Application for Planning Permission for Works or Extension to a Dwelling

Development: Retrospective application for fence.
Location: 6 Fairlands East Preston BN16 1LH

Location Plan Insufficient

Retrospective Planning Application: 6 Fairlands				
Location Plan and Block Plans				
DRAWN: MGE	SIZE A3	APPLICATION NO. EP/11/26/HH	DWG NO 2601-EAD-001	REV 3
DATE: 19/02/2026	SCALE	As indicated	SHEET	1 OF 5

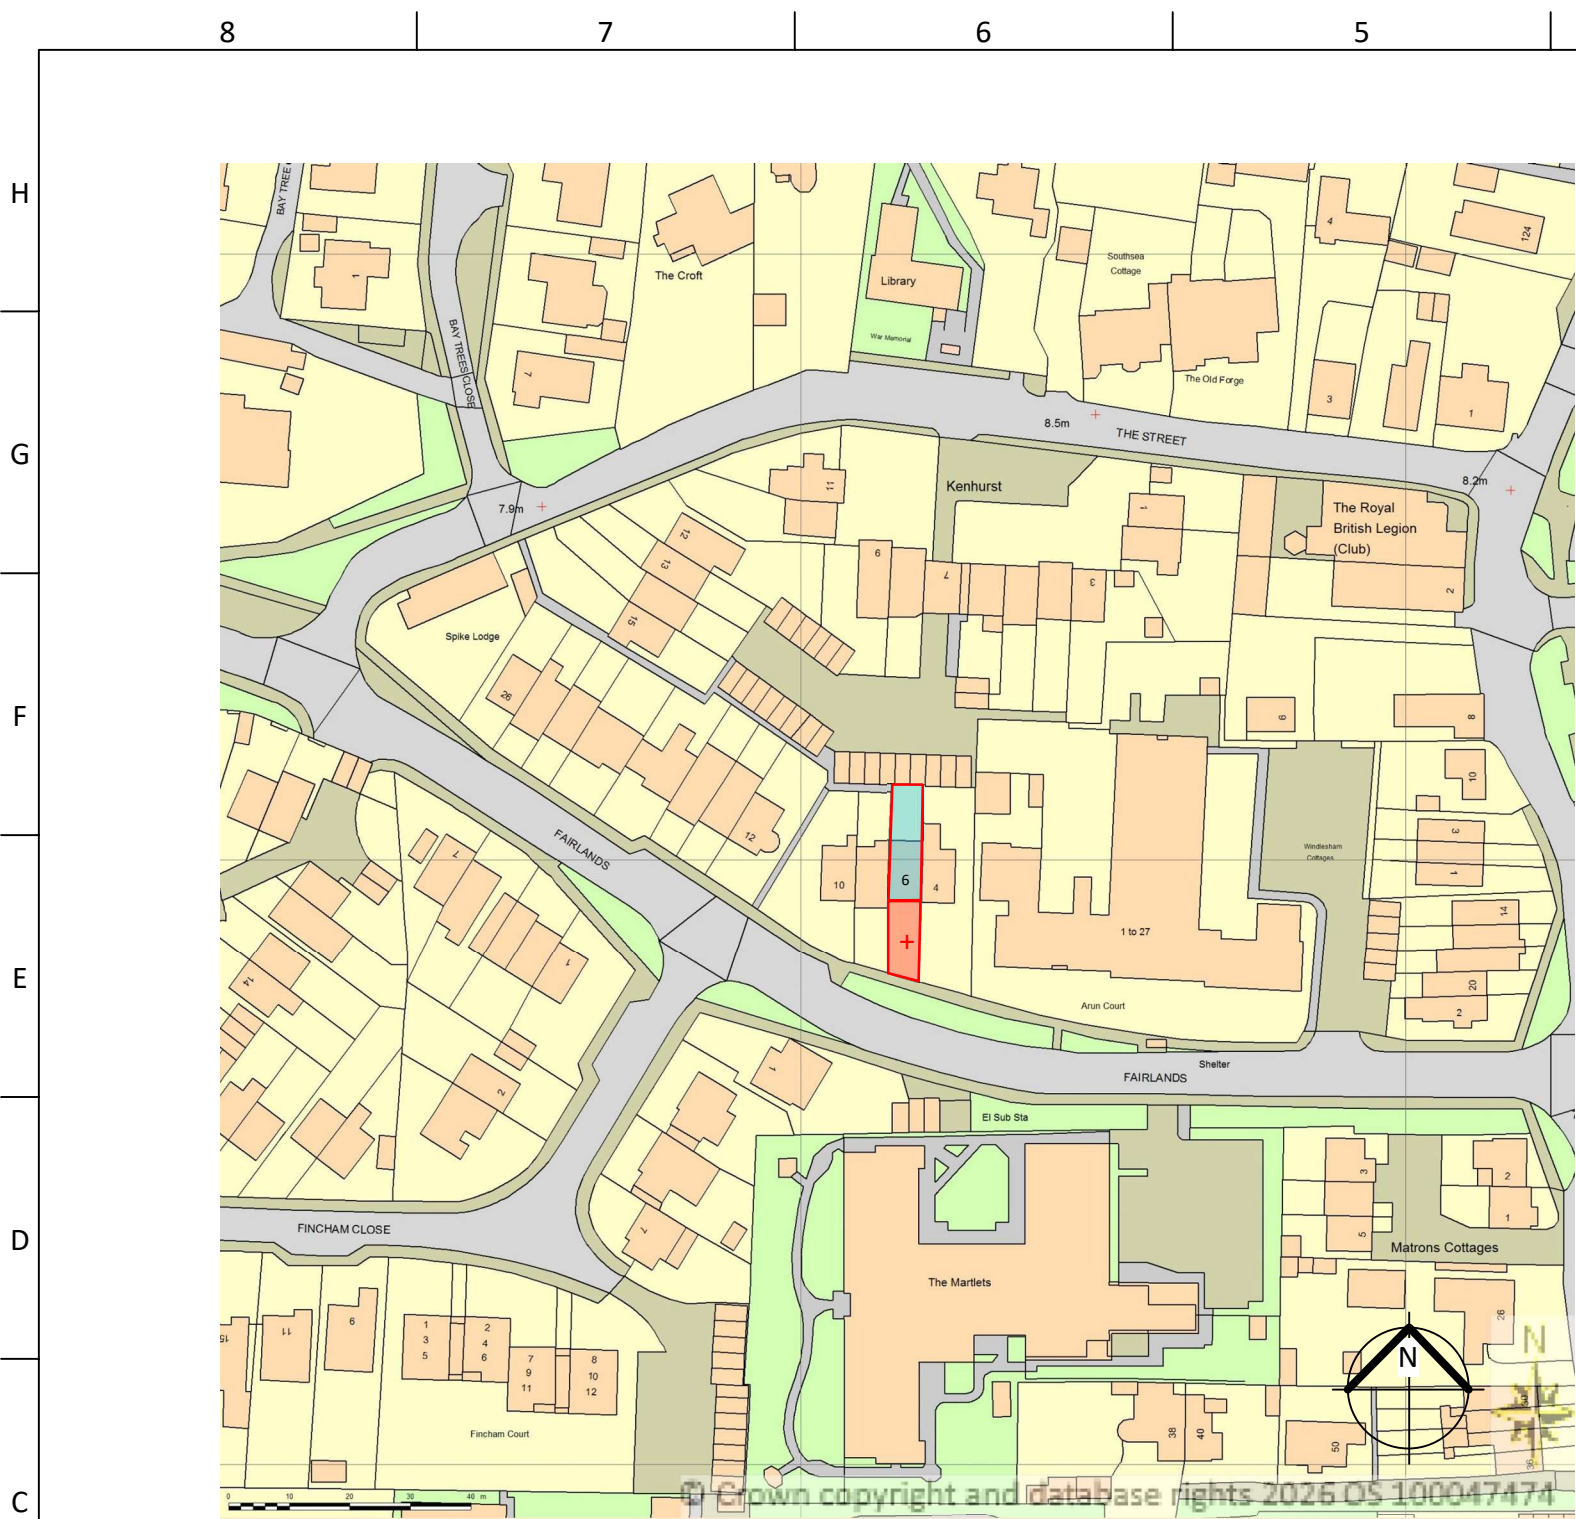
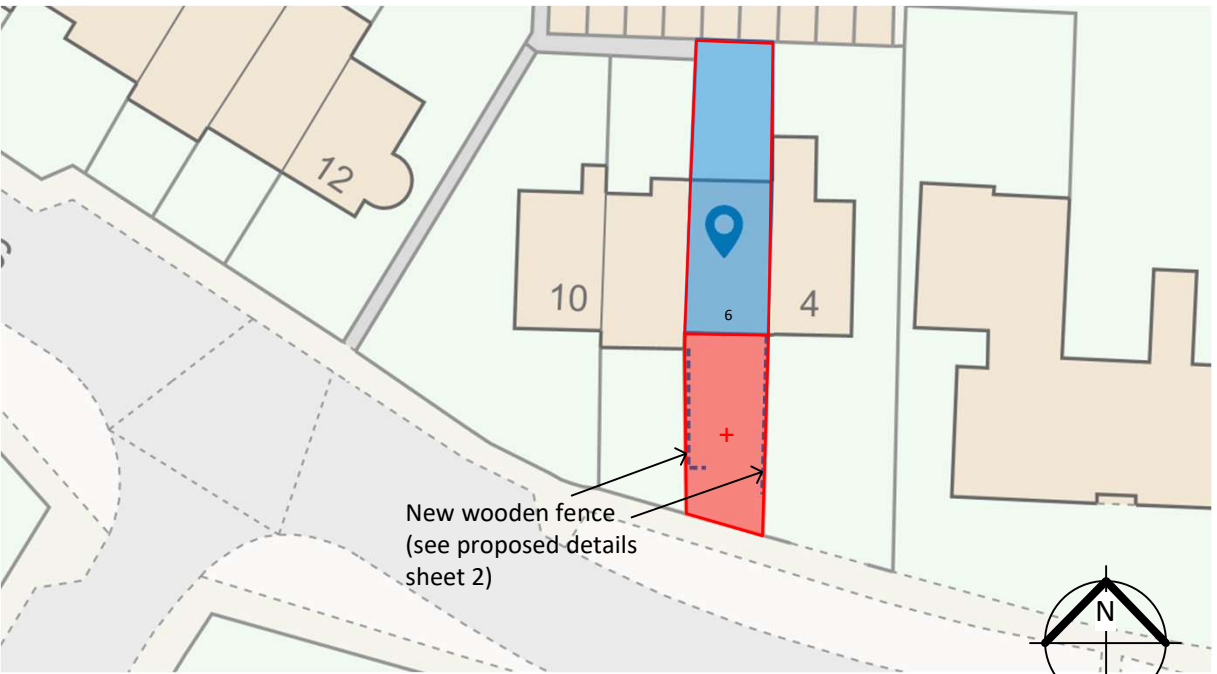
The location plan requires a solid red outline around the site boundary, please review and amend. Further details of what must be included on the plan can be found in the Validation Requirements List.

Retrospective Planning Application: 6 Fairlands			
	Proposed (modification of existing) and Existing – Plan and Elevation			
DRAWN: MGE	SIZE A2	APPLICATION NO EP/11/26/HH	DWG NO 2601-EAD-002	REV 3
DATE: 19/02/2026	SCALE 1:100	SHEET 2 OF 5

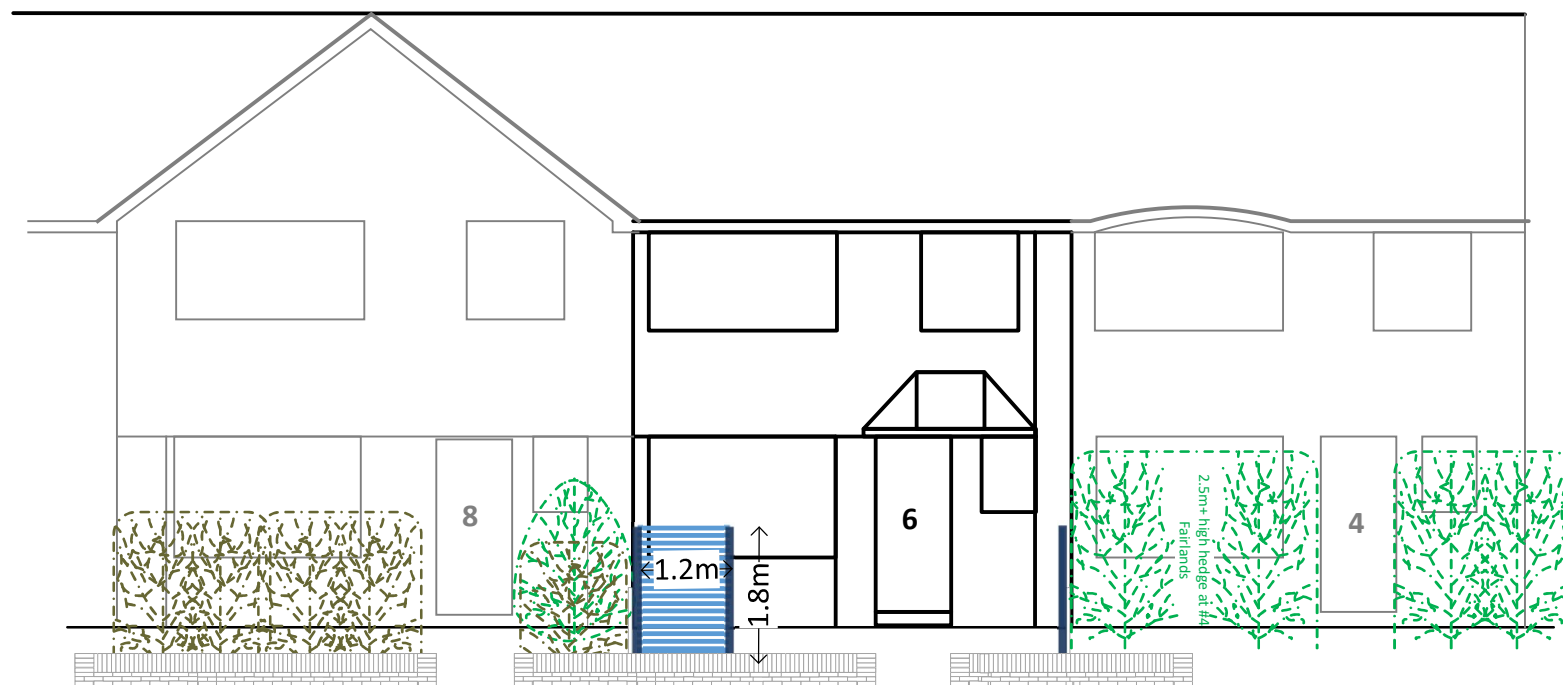
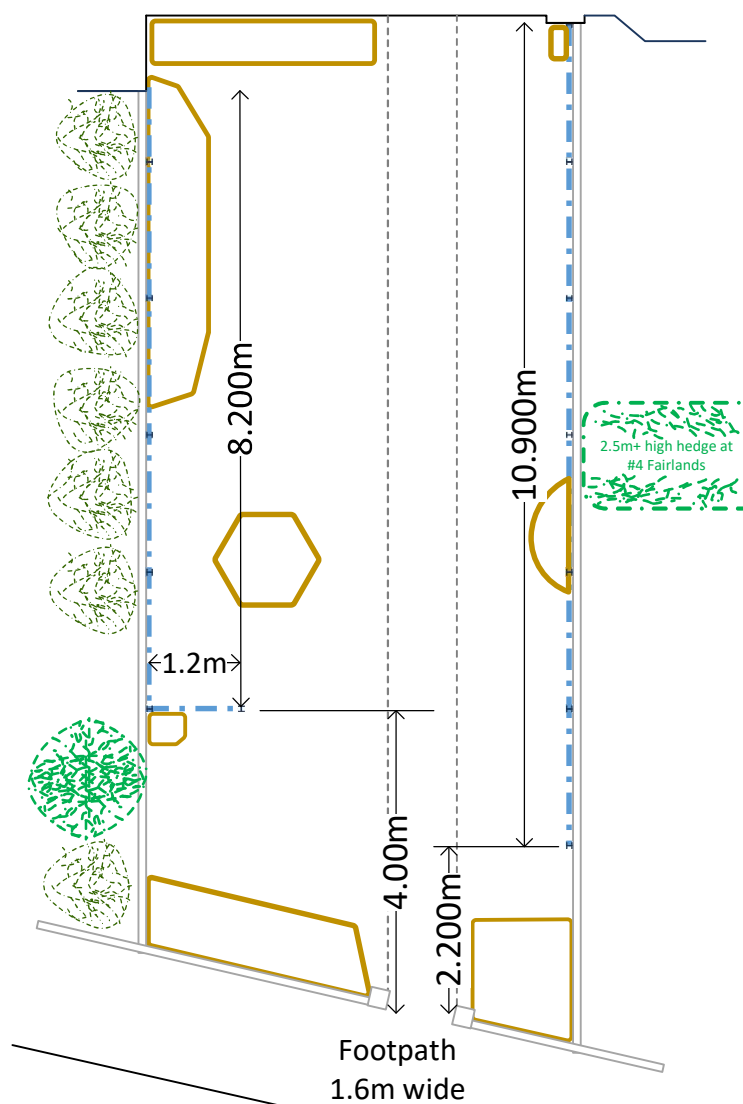
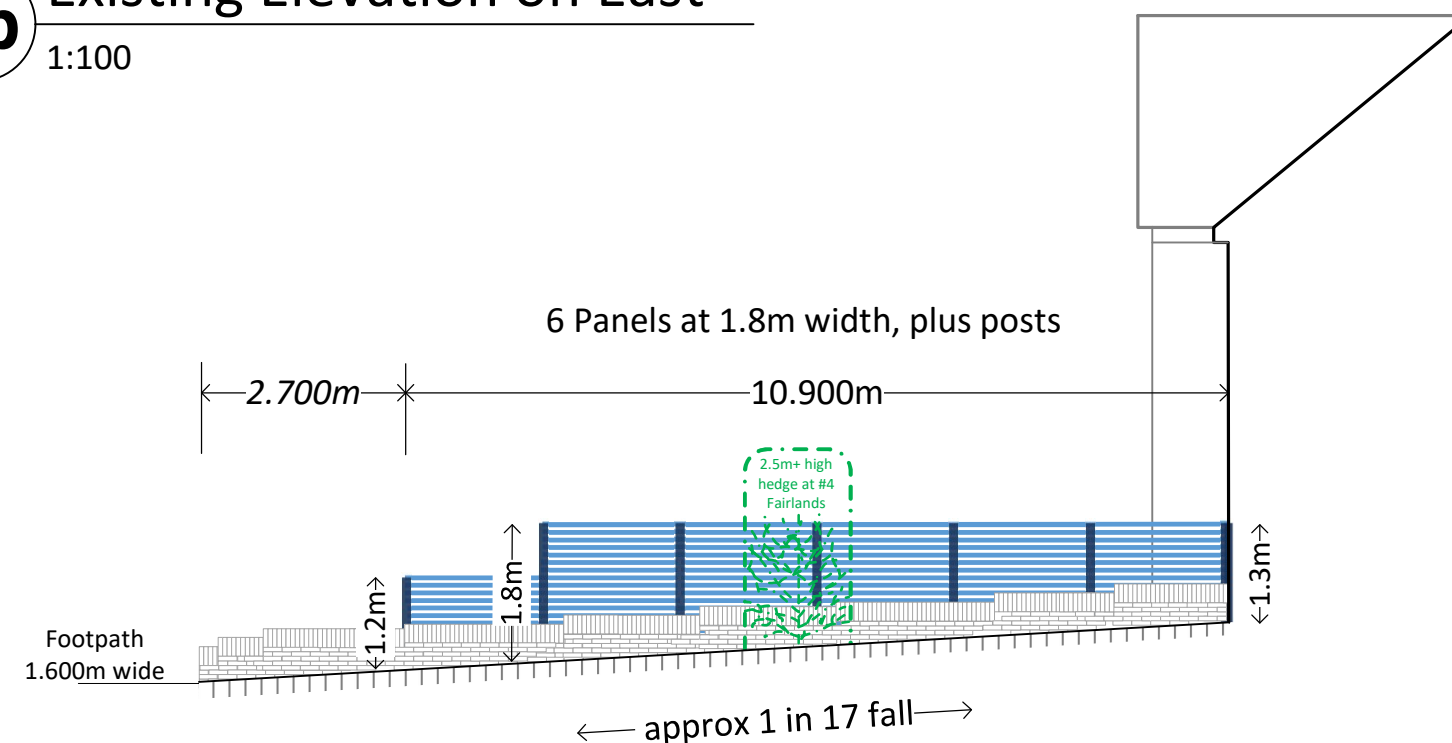
Proposed Plans

Please re-label the proposed plans to existing.
